**UNSW Health Translation
Hub**

**SSDA Access
Review – Final**

24th February 2021

scale	1 : 250@A1	drawing no.	DA1001
drawn	TH	issue	
checked	JC		
project no	190551.00		A

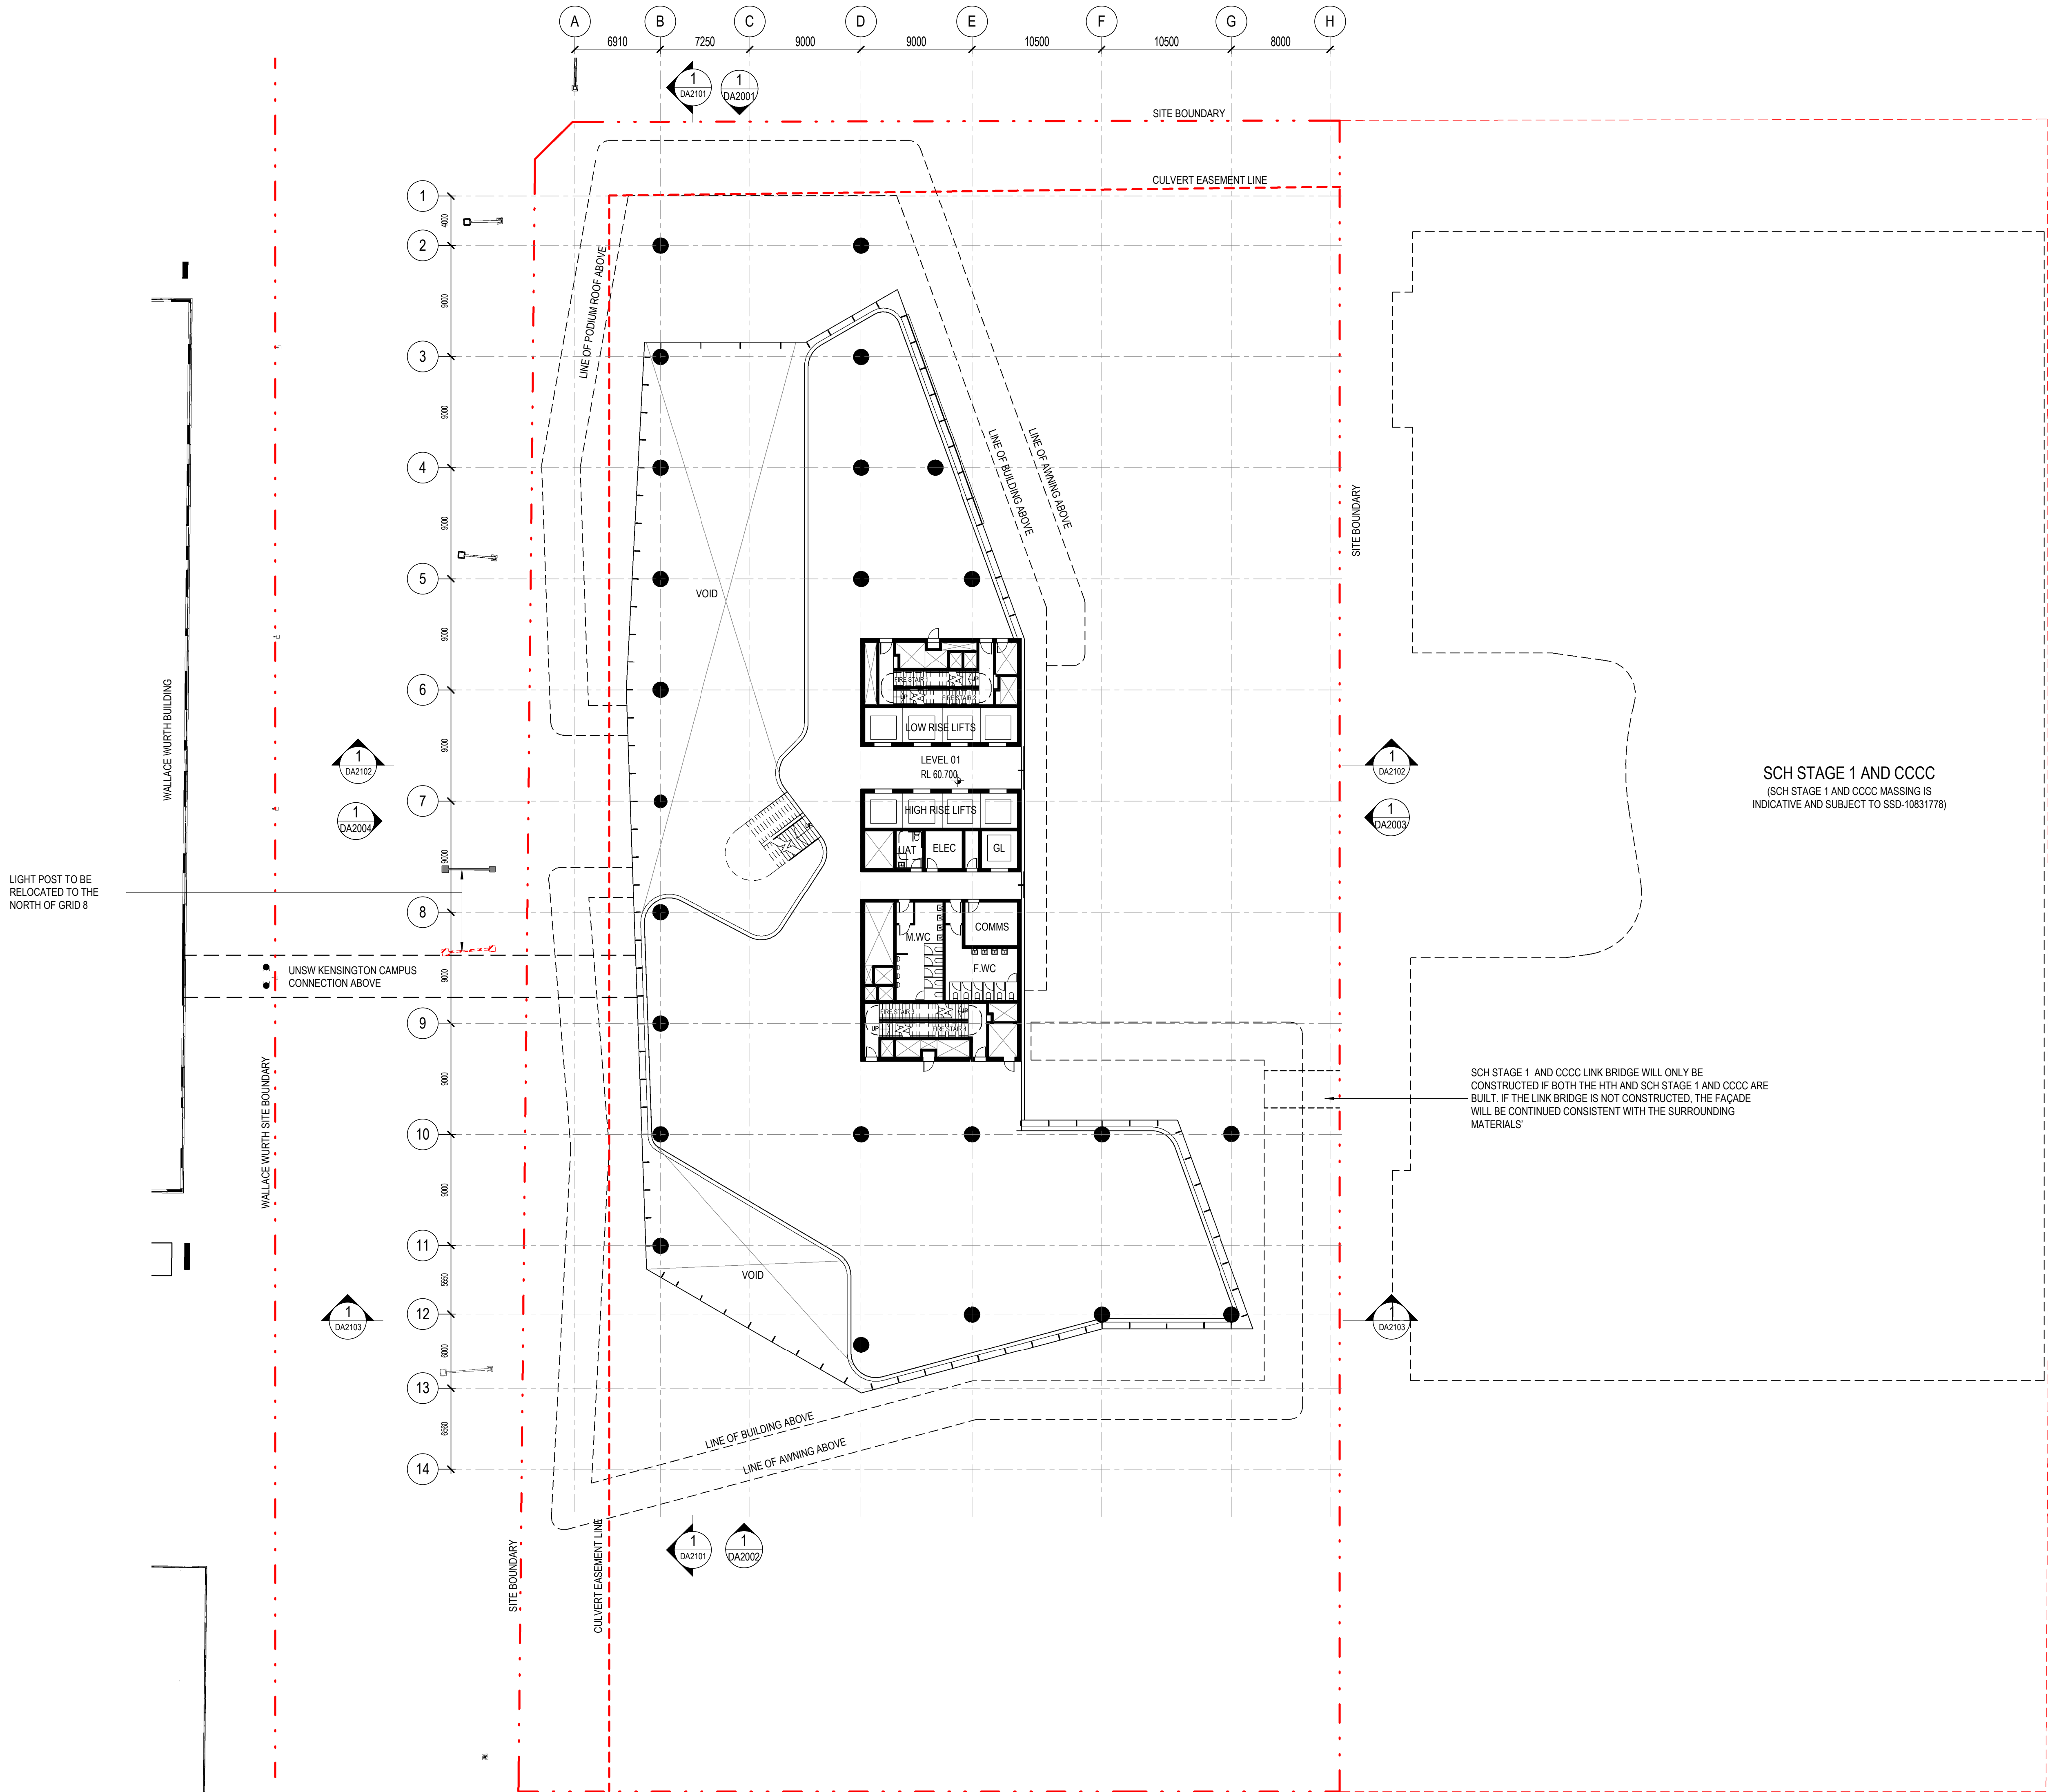
There are two main access points to the site from Botany Street. The south eastern entry consists of a stair with adjacent ramp providing access to the main entry door from the Botany Street pedestrian footpath. The stair has provision for handrails that will not interfere with the surrounding circulation paths of travel compliant with AS1428.1. The adjacent ramp has provision for landings and handrails that comply with AS1428.1. TGSIs are achievable at the top and bottom landings of both the stair and ramp compliant with AS1428.4.1.

The north eastern entry consists of a stair with adjacent ramp providing access to the main entry door from the Botany Street pedestrian footpath. The stair has provision for handrails that will not interfere with the surrounding circulation paths of travel compliant with AS1428.1. The adjacent ramp requires review to allow for compliant handrails on both sides compliant with AS1428.1. Currently the disappearing stair adjacent the ramp will interfere with the provision of compliant handrails on both sides. TGSIs are achievable at the top and bottom landings of both the stair and ramp compliant with AS1428.4.1.

On the basis of the current level of detail all access requirements appear capable of achieving compliance. Amendments can readily be incorporated at Crown Certificate stage to ensure compliance with relevant codes.

scale	1 : 250@A1	drawing no.	Level 02
drawn	TH	DA1003	
checked	JC	issue	
project no	190551.00	A

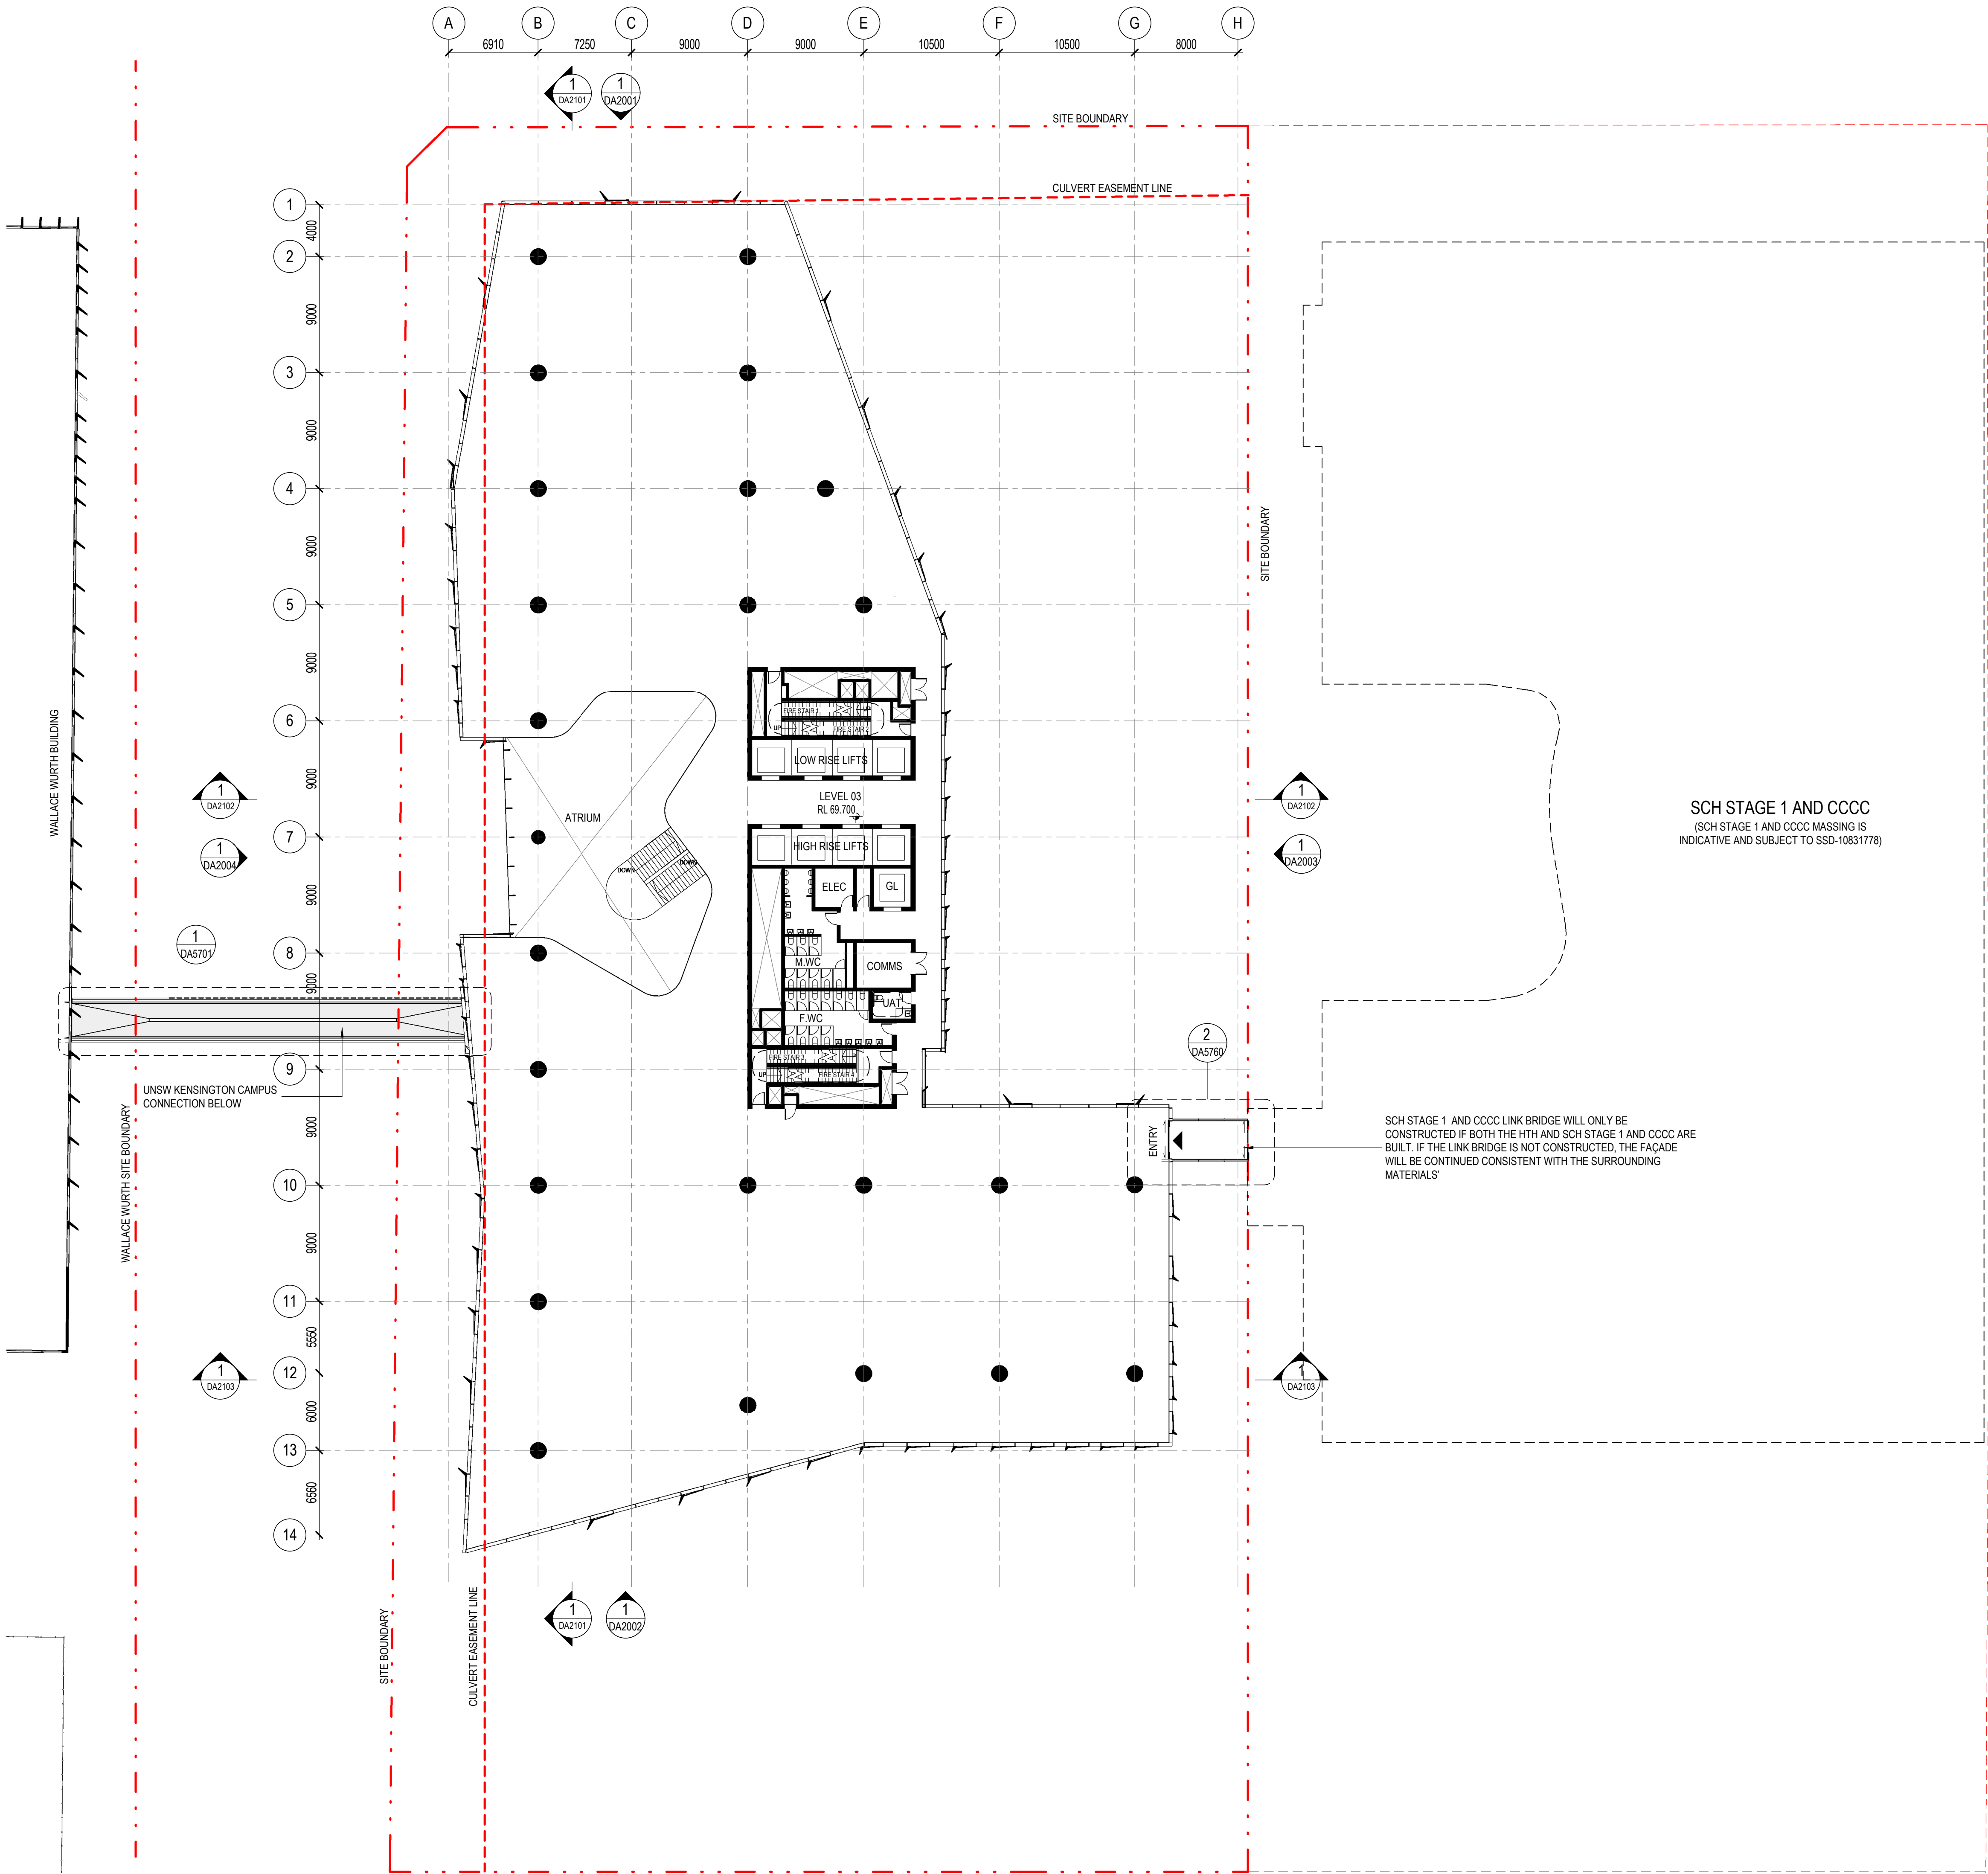
The UNSW campus connection on Level 02 can achieve compliance with AS1428.1 as an accessible path of travel from the associated UNSW site.
